**Summary of HVPC comments on application 2023/62/91212/W**  
**- proposed Bankfield Drive development, Holmbridge.**  
**December 2023**

This is the second time Holme Valley Parish Council Planning Committee have commented on this development proposal, please also see our comments outlining concerns from the meeting on 22 May 2023. Given the large number of neighbour representations, it is a matter of regret that there was no prior consultation between the developers and the Parish Council or local residents. Had this taken place, at least some of the concerns that are currently being expressed by residents might have been addressed in advance of submitting this revised application.

PROJECT	CLIENT				
BANKFIELD DRIVE, HOLMBRIDGE	ORION HOMES				
DRAWING TITLE	CHECKED	APPROVED	DRG No.		
	PO	PO	22027/GA/01		
	DRAWN BY:	SCALE @ A2	DATE	REV.	
DOBB TOP ROAD/ BANKFIELD DRIVE PROPOSED IMPROVEMENTS	SG	1:200	NOVEMBER 2023	D

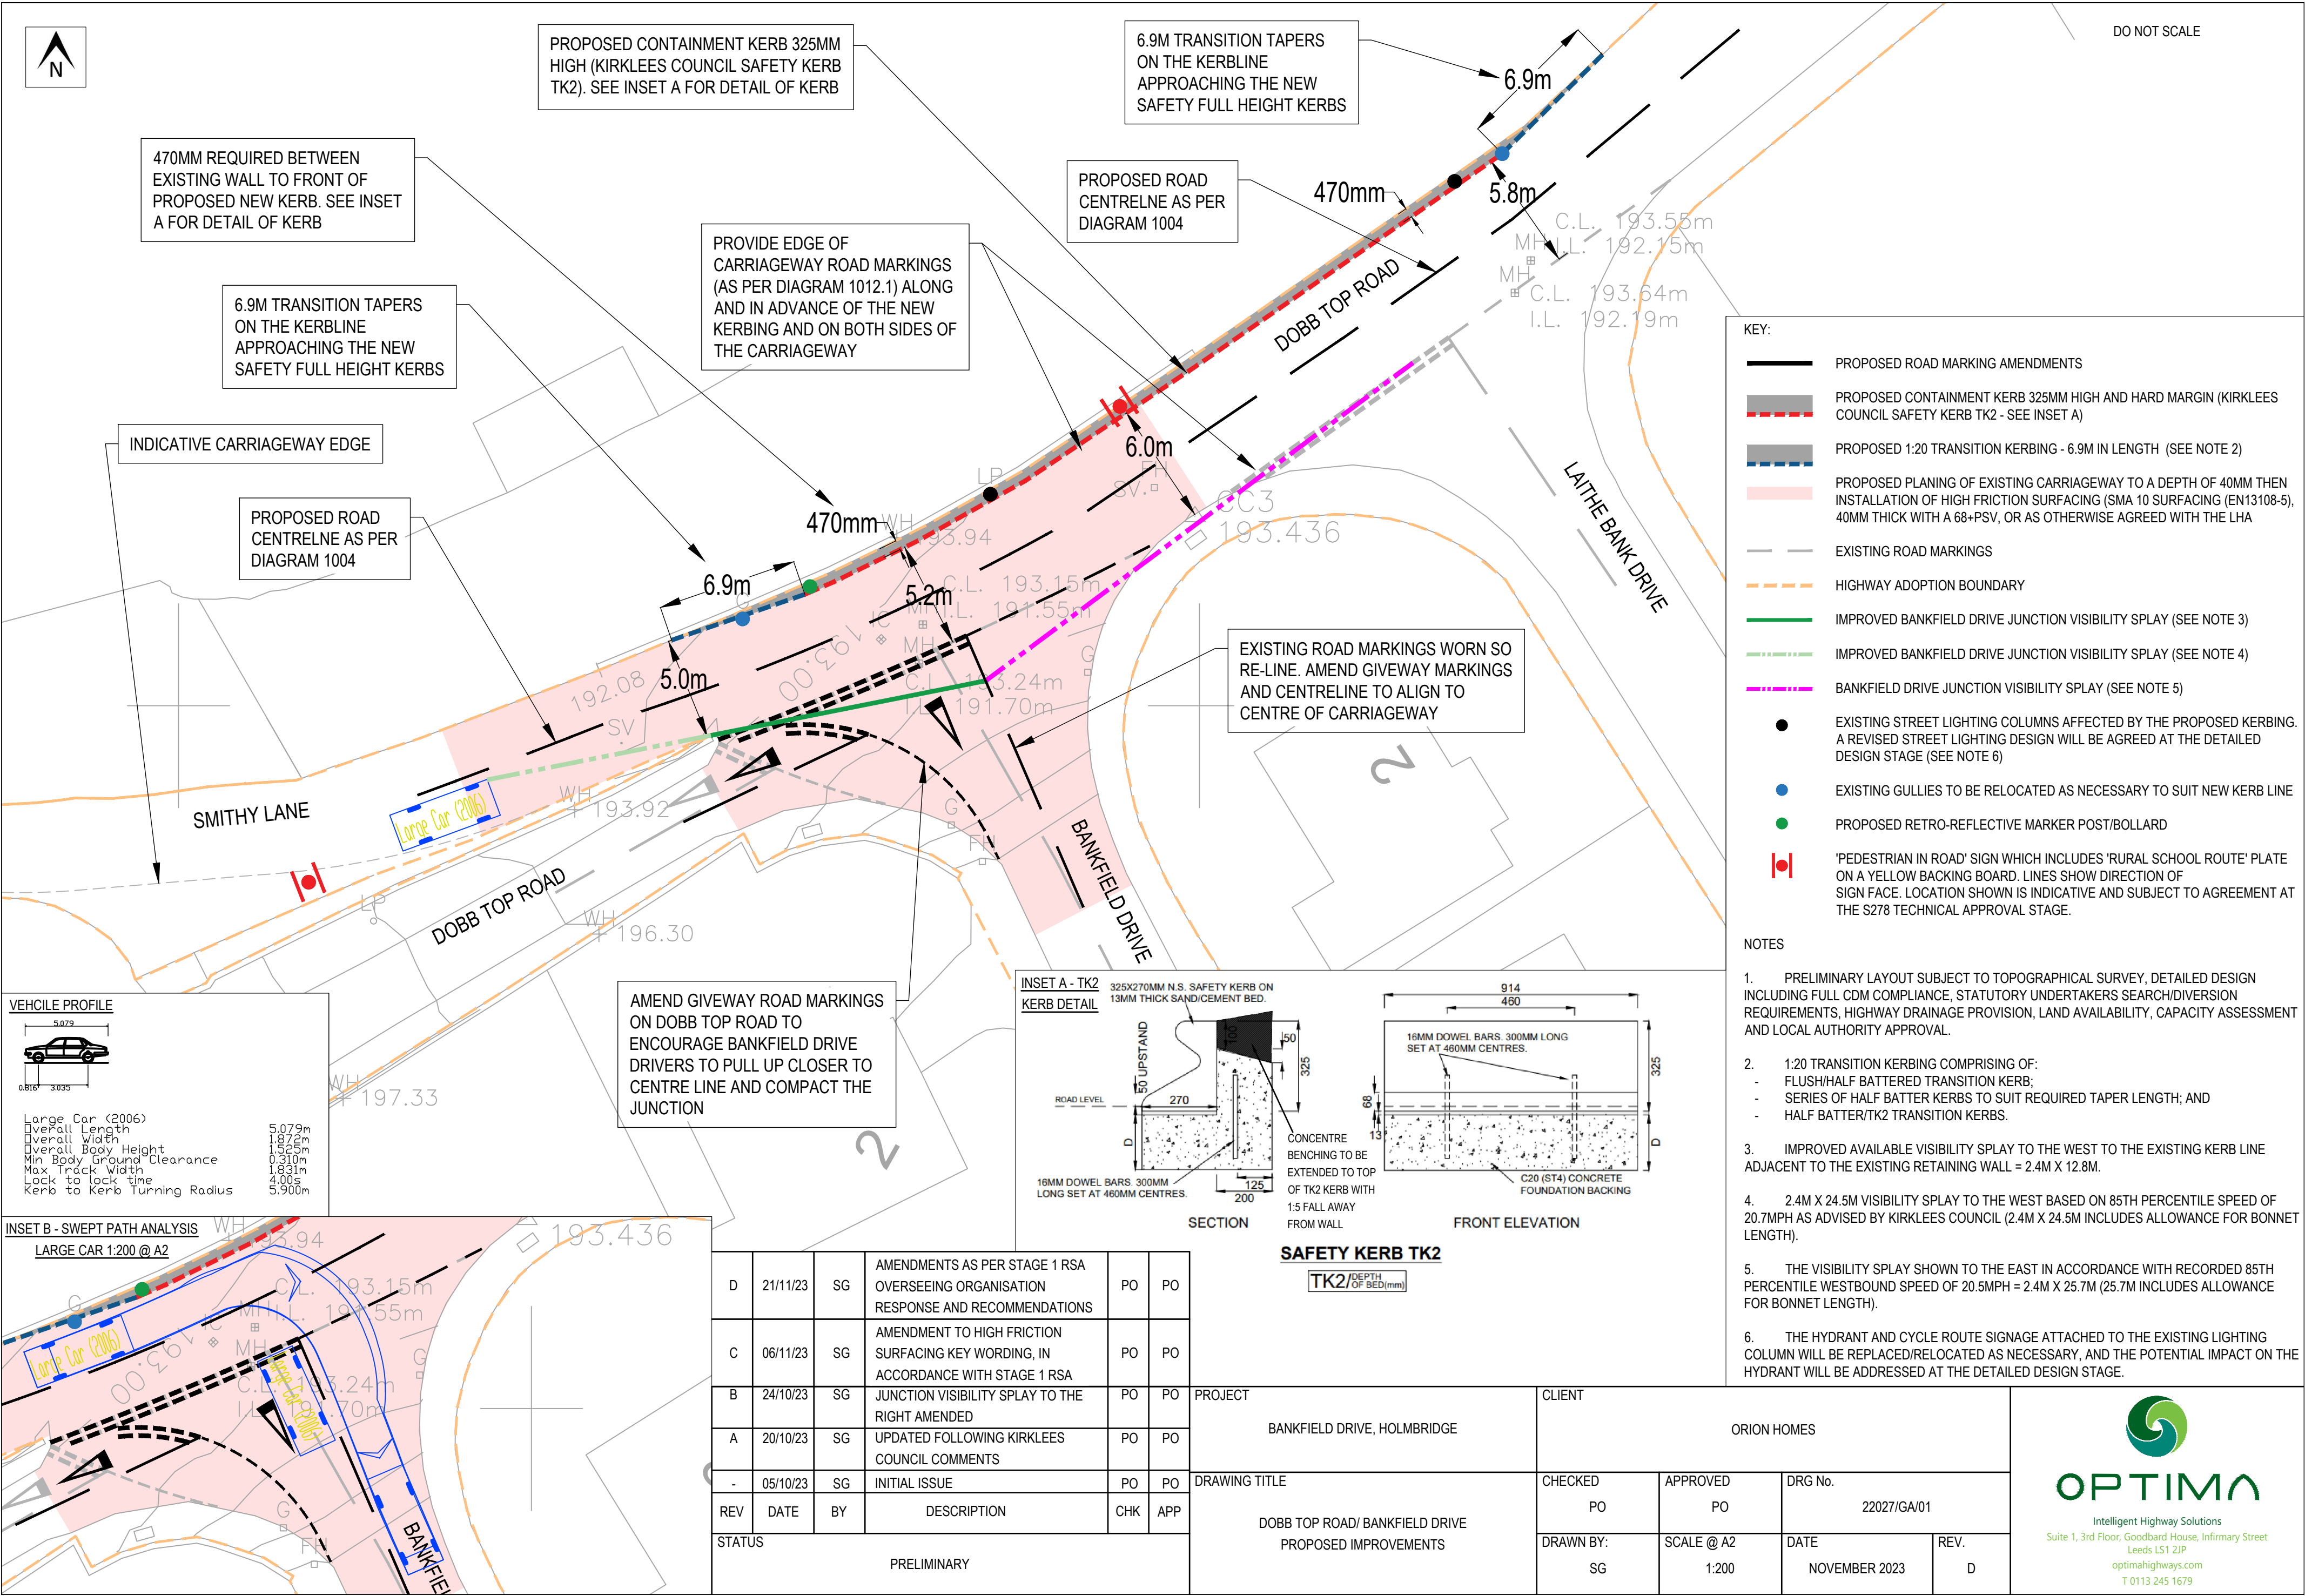
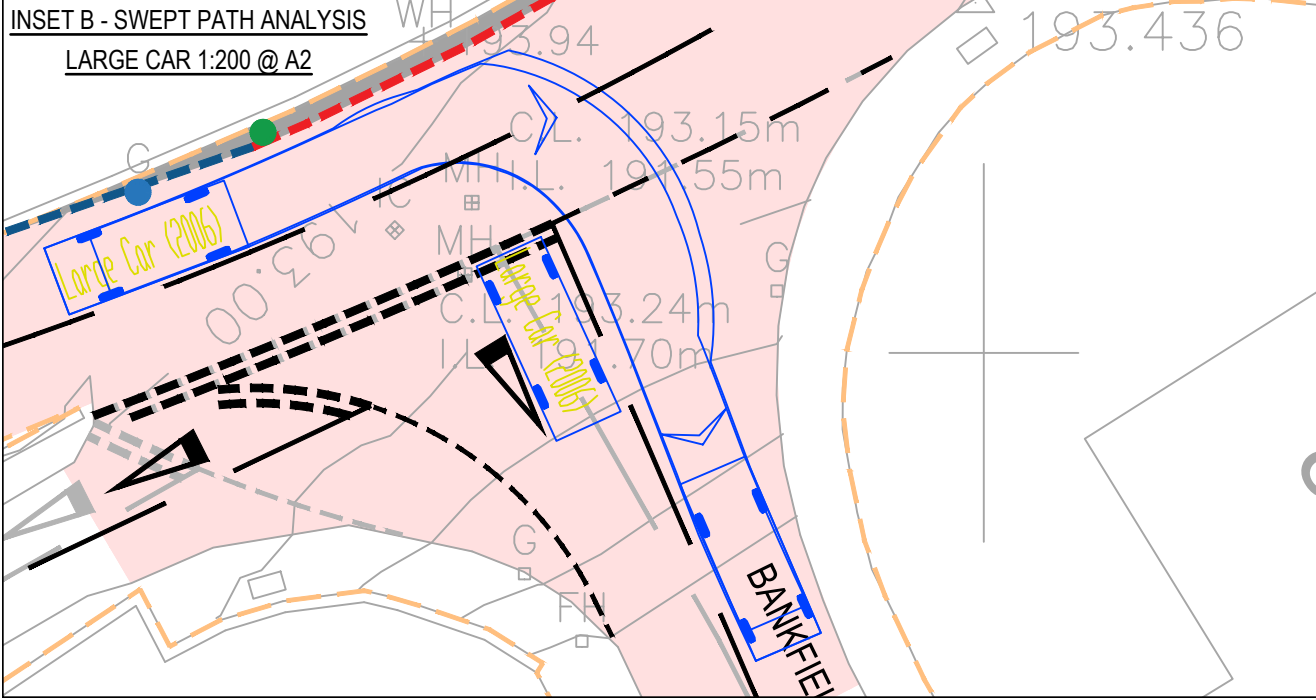
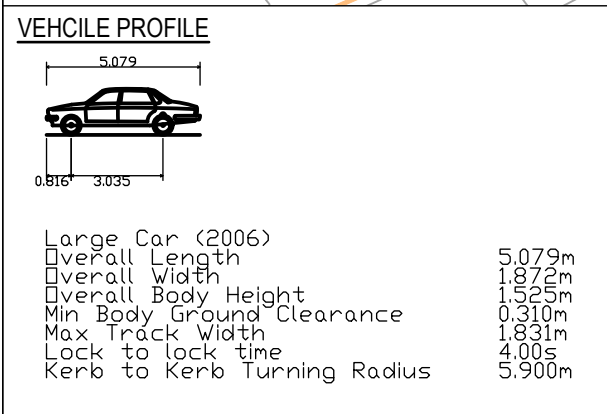
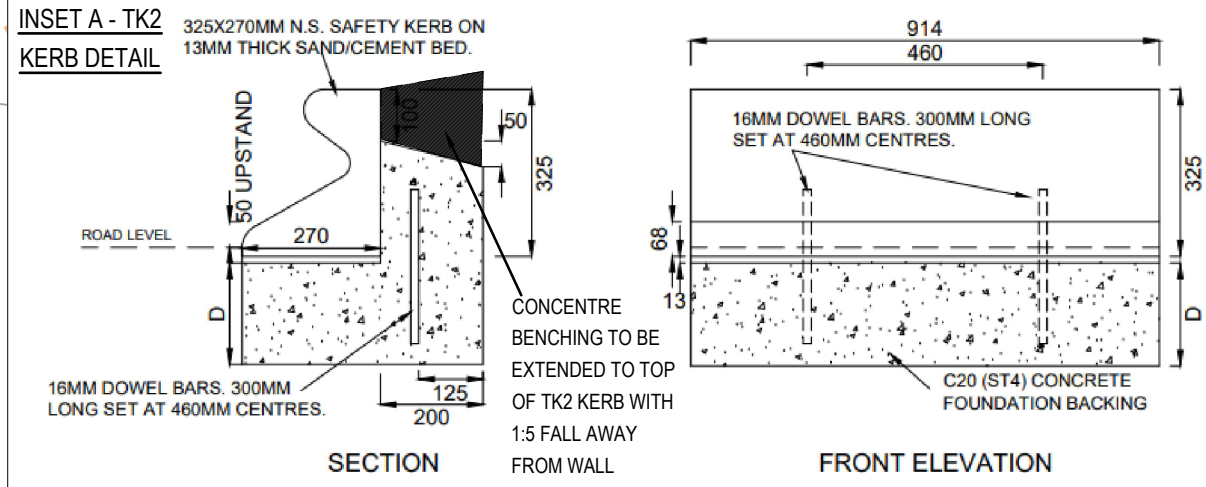
The introduction of an anti-skid/high-friction surface at the junction of Bankfield Drive and Dobb Top Road whilst welcome will likely not be sufficient to reduce the risk of skid-related accidents when the road is covered with snow and ice, remembering that neither Bankfield Drive nor Laithe Bank Drive are gritted during winter months.

In addition, it should also be noted that the proposed installation of a 325mm high safety kerb to address this issue will reduce the width of an already narrow road by approximately 0.5 metre. The installation will also require substantial infill work up to the boundary stone wall because of the steep camber that has developed on the northern side of the road.
